Date: 08-Jan-2025
Our Ref: 2024/93436

**TOWN AND COUNTRY PLANNING ACT 1990
TOWN AND COUNTRY PLANNING (GENERAL PERMITTED DEVELOPMENT) (ENGLAND)
ORDER 2015 – SCHEDULE 2, PART 1, CLASS A.1 (g)
AT: 5, Stone Acre Heights, Meltham, Holmfirth, HD9 4EF
Prior notification for single storey rear extension**

The Authority has considered your application and it has been determined that the proposal is not acceptable and prior approval is hereby **Refused** for the following reason(s);

GENERAL ARRANGEMENT AS PROPOSED FLOOR  
PLANS & ELEVATIONS

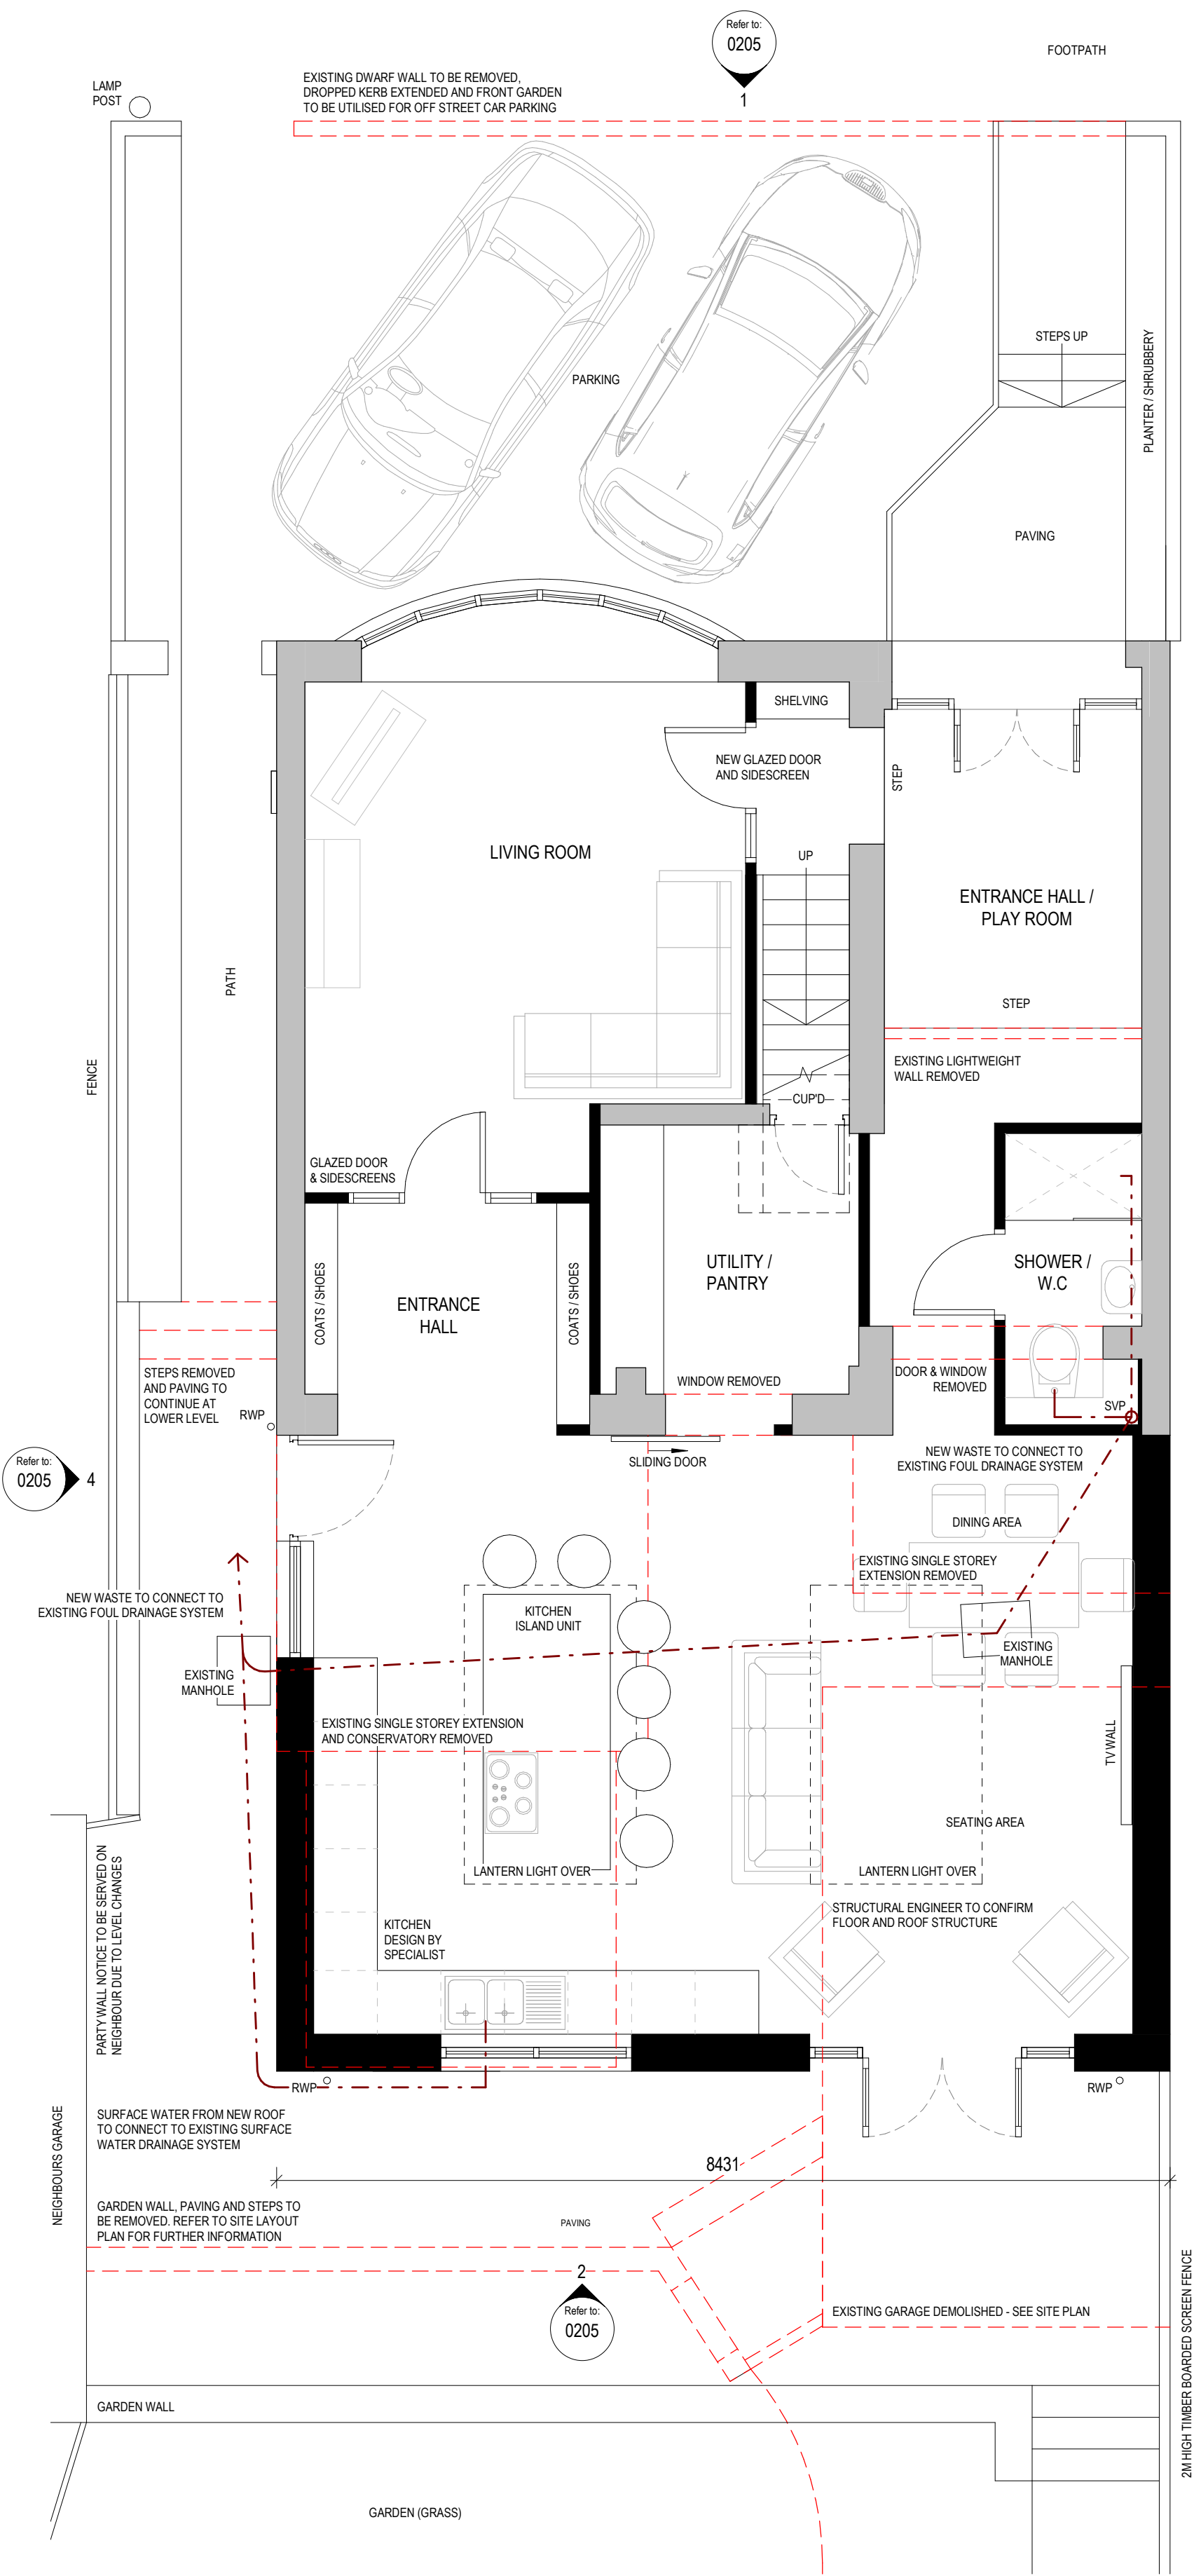
The proposed enlargement does not benefit from a general planning permission under Article 3(1) and Class A, Part 1 of Schedule 2 of the Town and Country Planning (General Permitted Development) (England) Order 2015 (as amended) as the rear projection extends beyond a wall forming a side wall of the original dwellinghouse and has a width greater than half the width of the original dwellinghouse contrary to sub-paragraph A.1(j) of Class A.
